Suffolk County Council (20050784)

Final Position Statement

North Falls (EN010119)

23 July 2025

Visualisation showing cumulative development, including year 1 planting - (90 degree view)

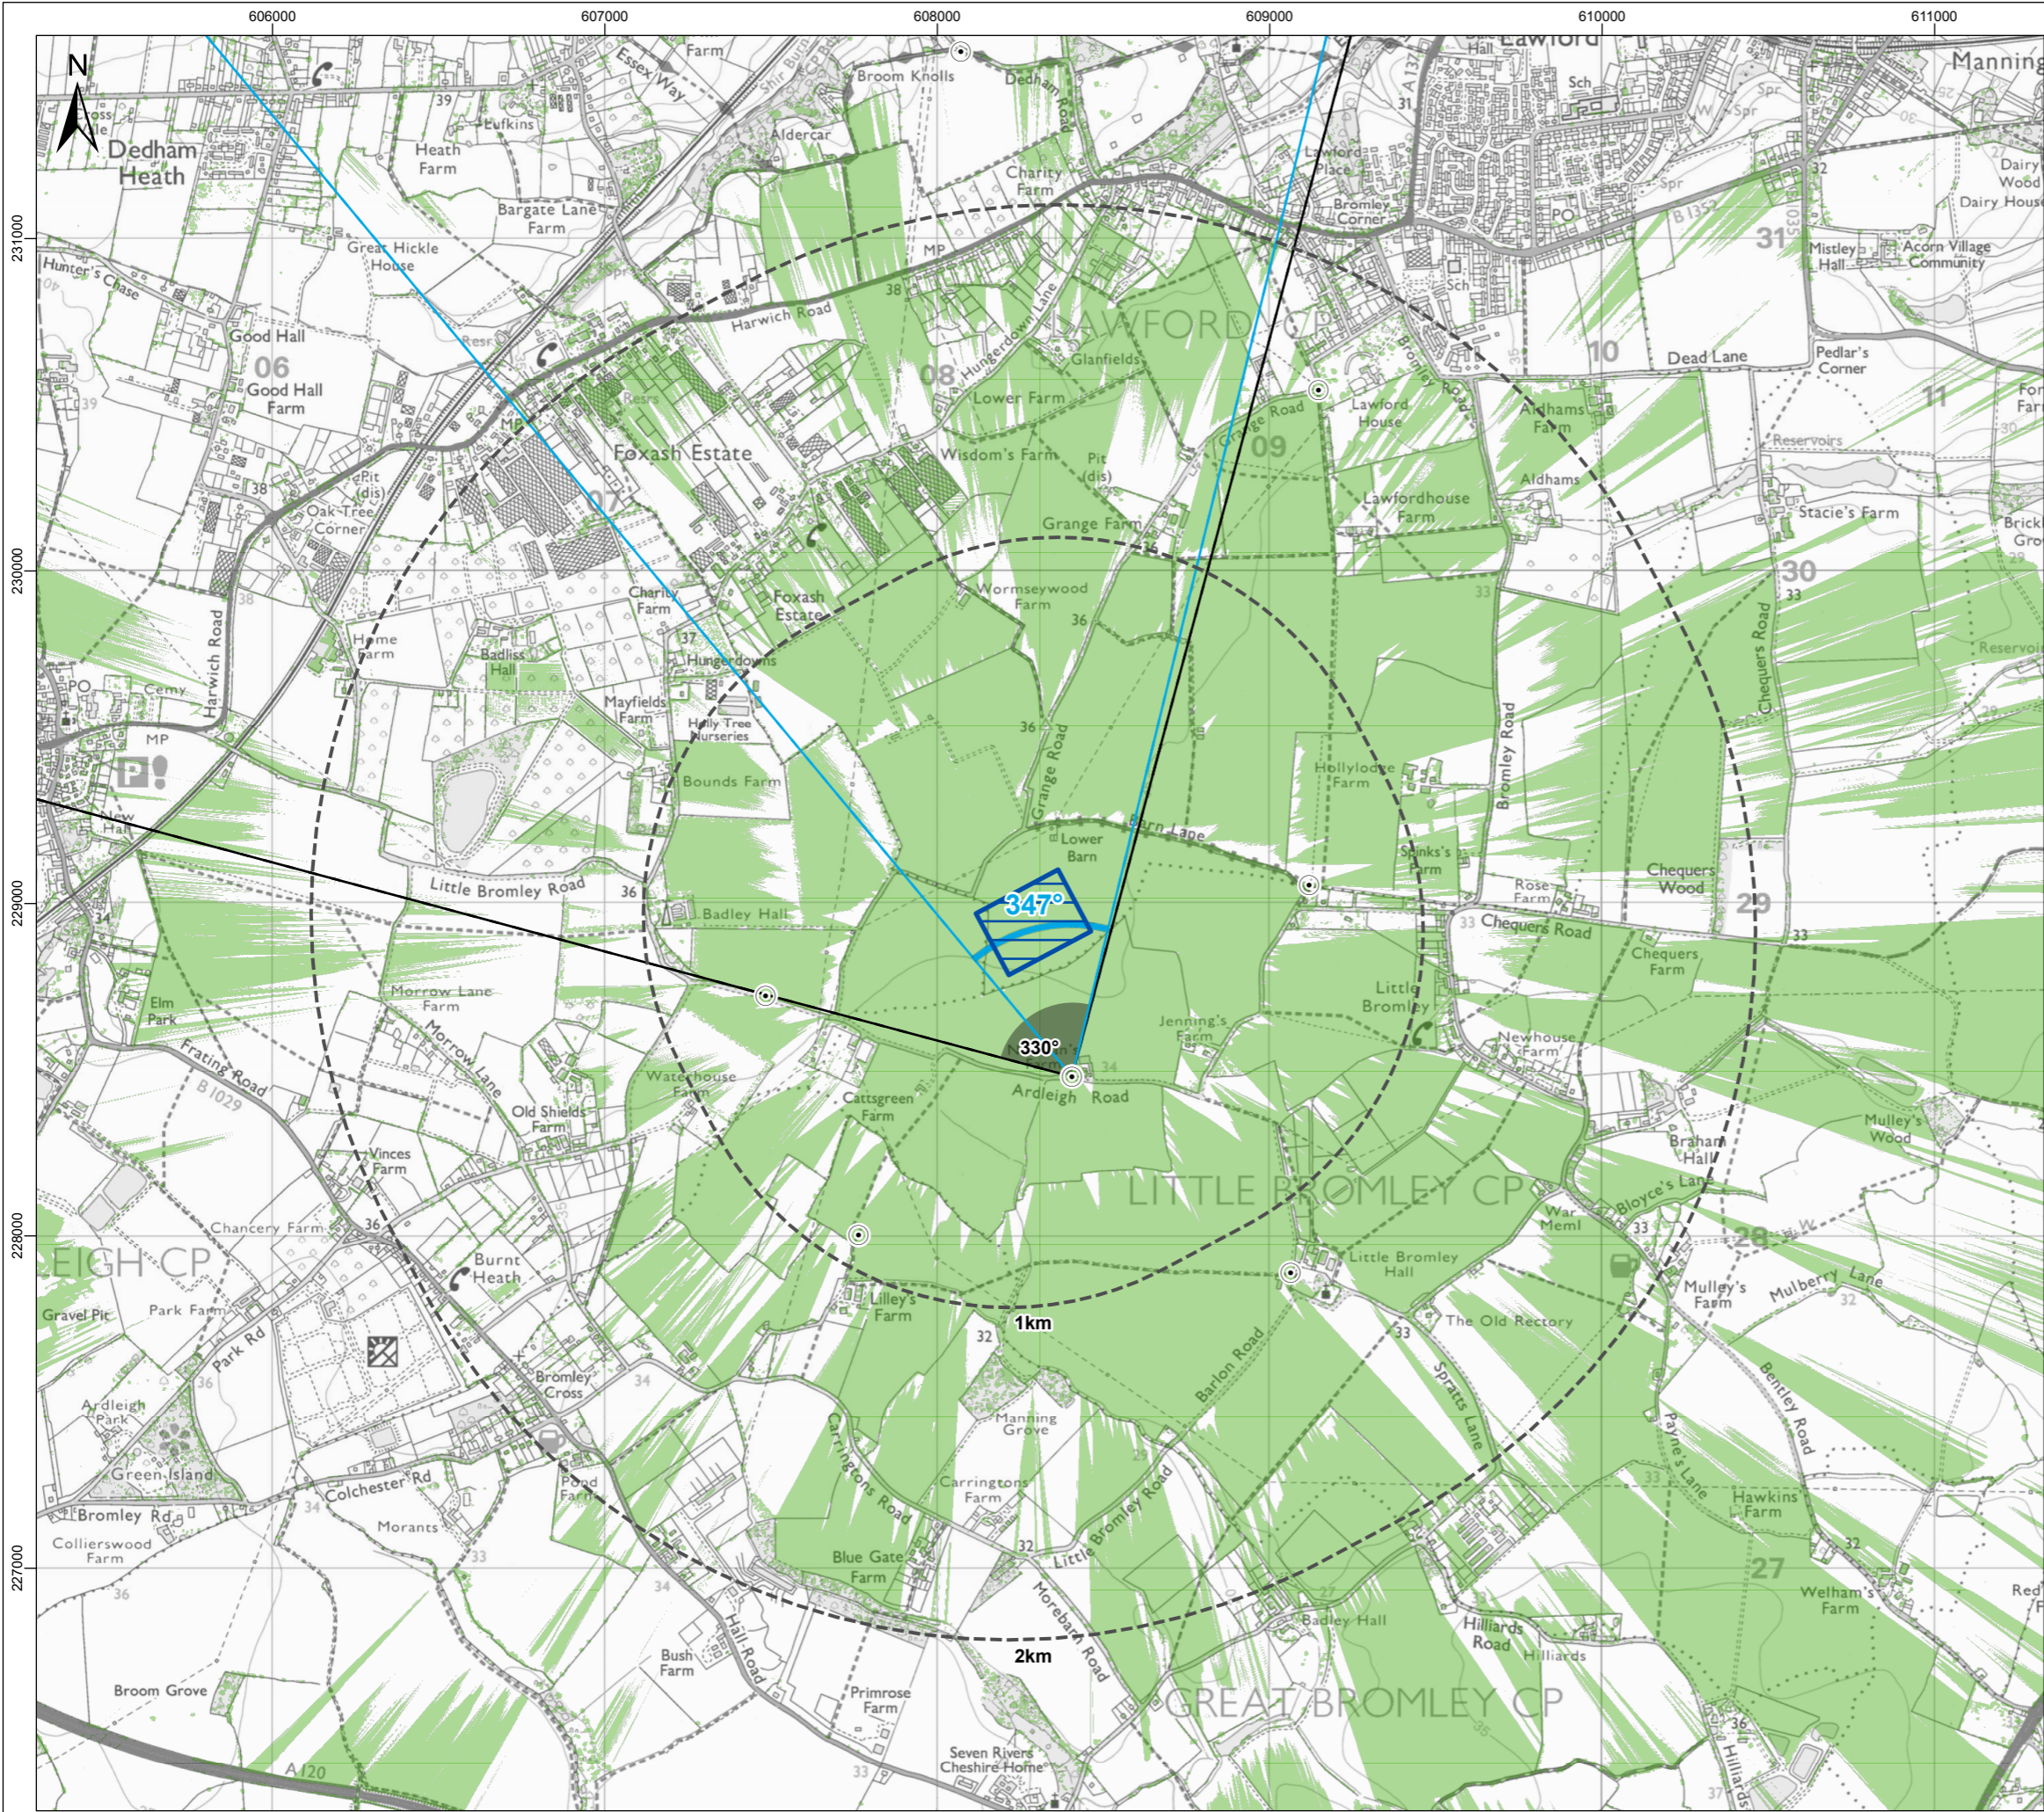
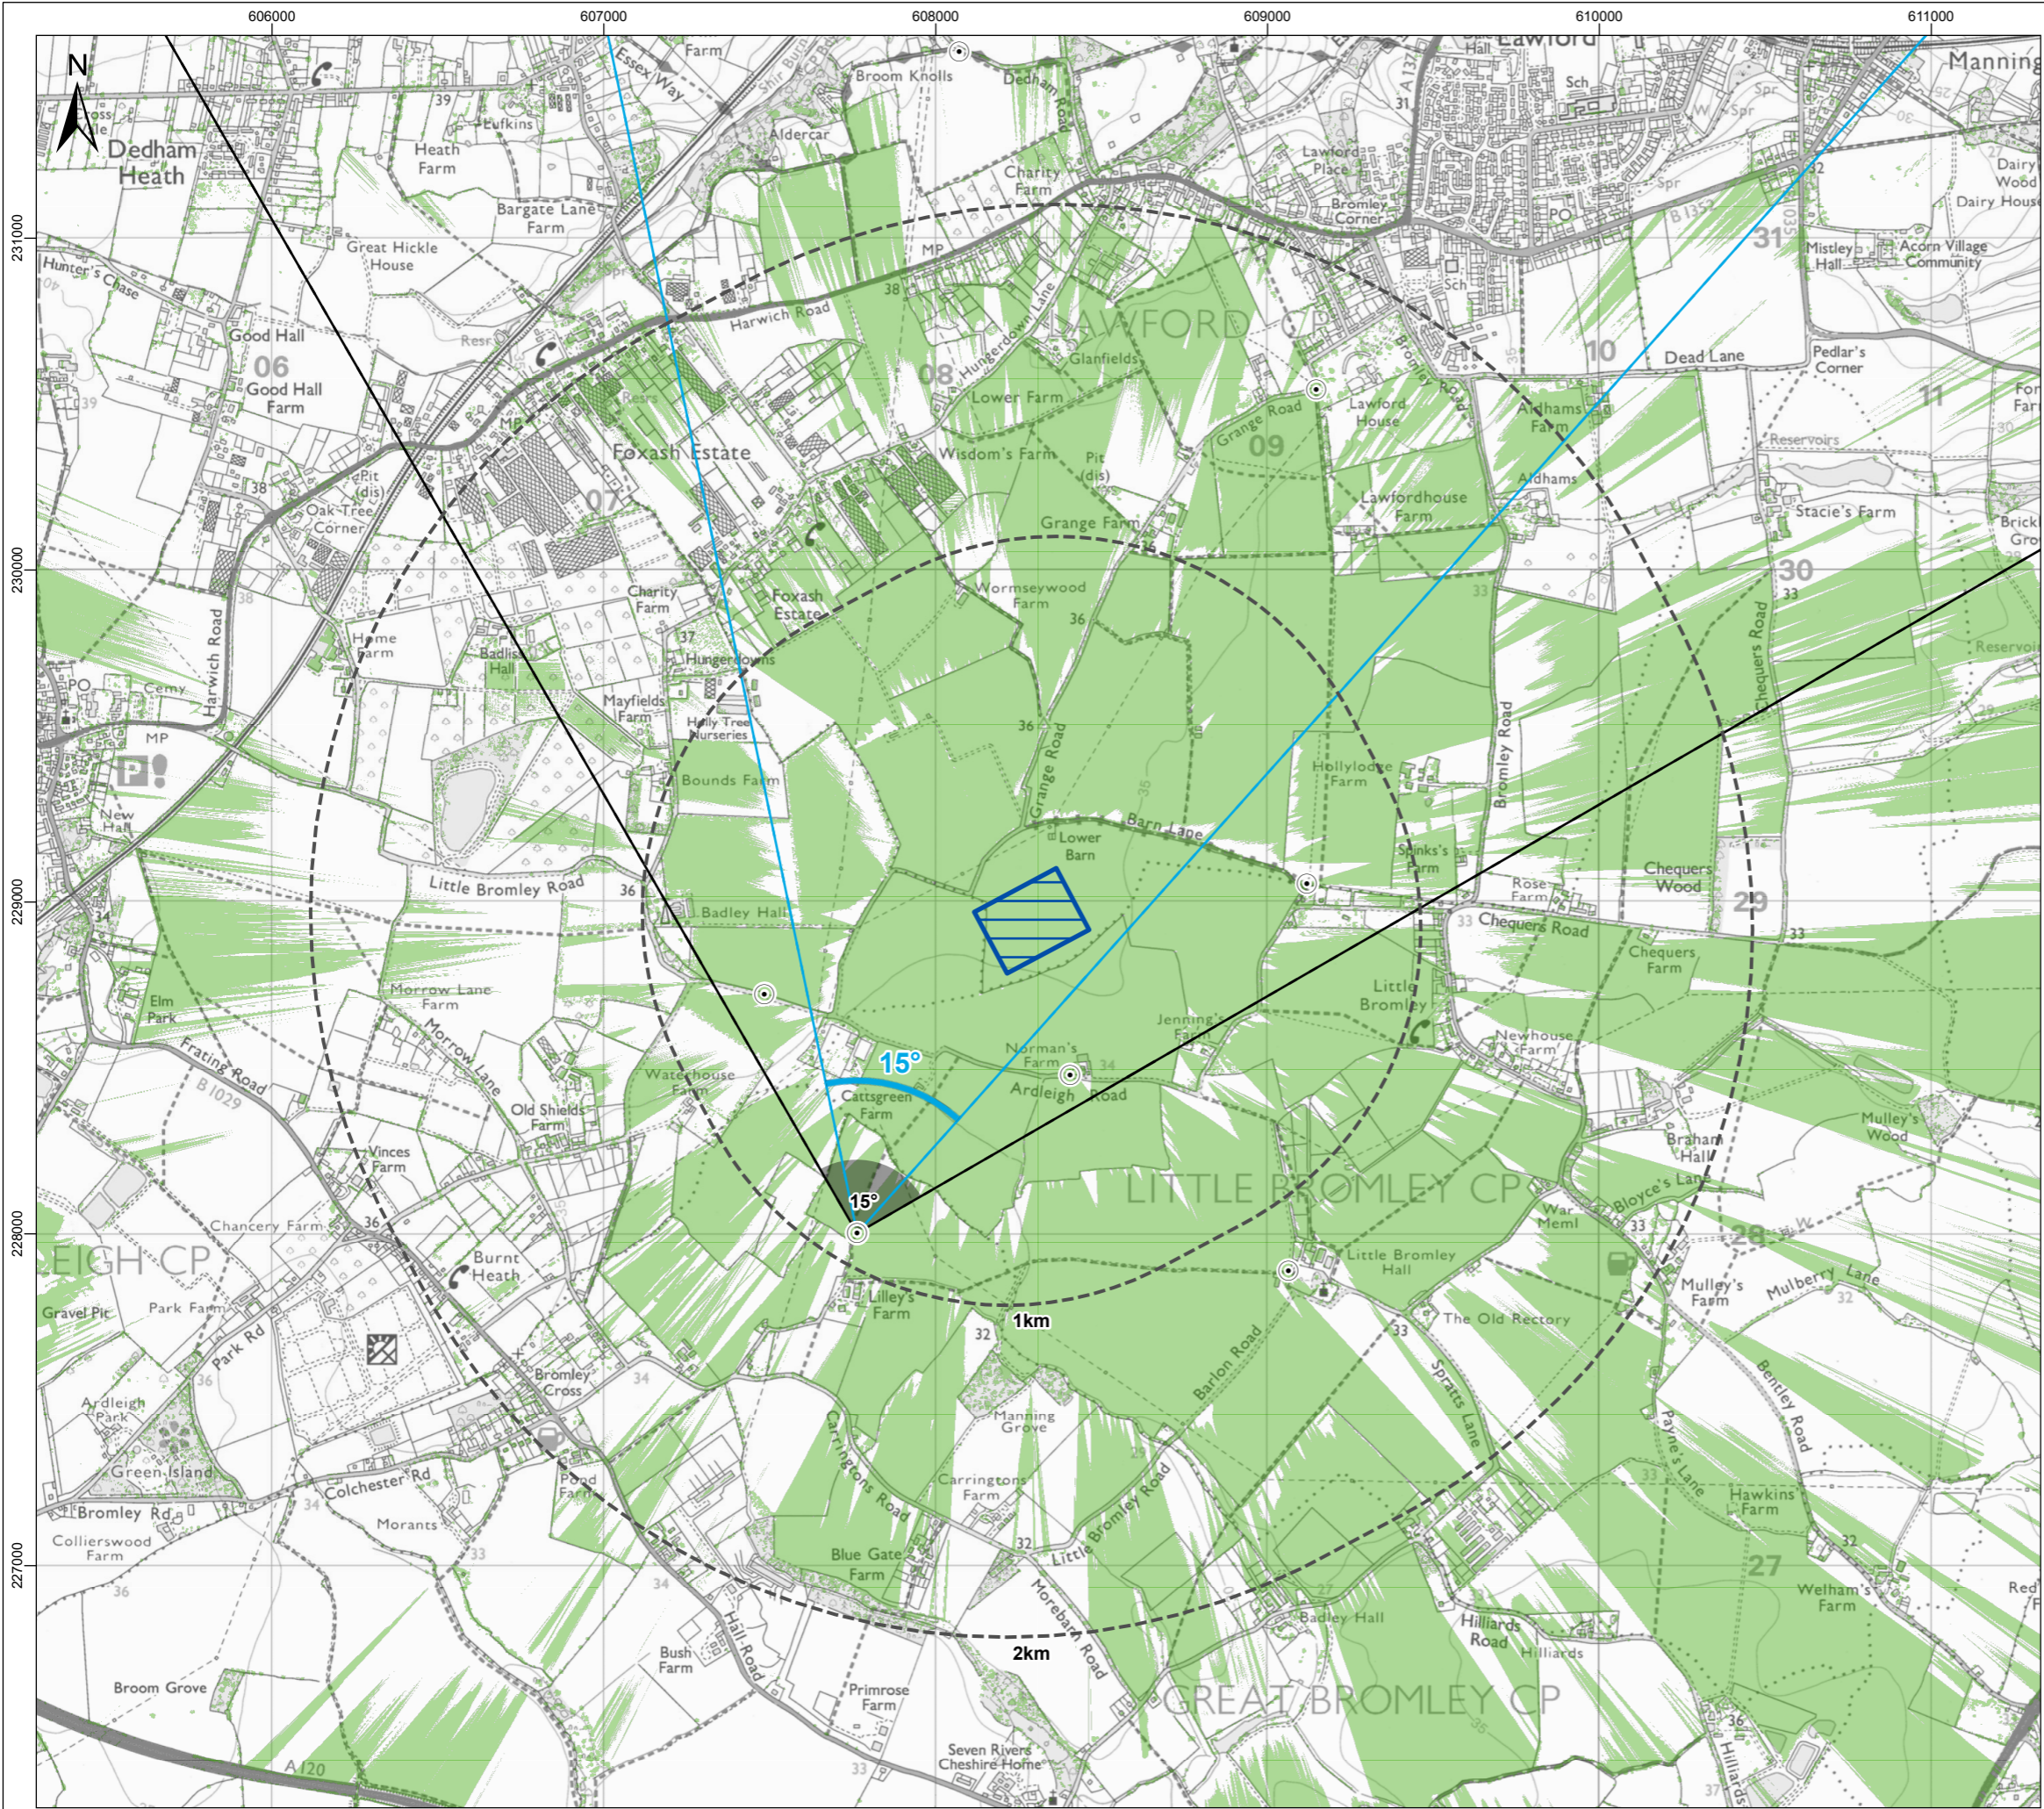
- 5.2 At deadline 4, the Applicant produced wirelines to display the effects of the project in combination with the pylons of Norwich to Tilbury [REP4-030]. SCC responded to this document in its response to deadline 4 submissions [REP5-116], welcoming the additional wirelines but reiterating the point that there remain unassessed zones of theoretical visibility which undermines the robustness of the cumulative effects assessment of the DVNL.
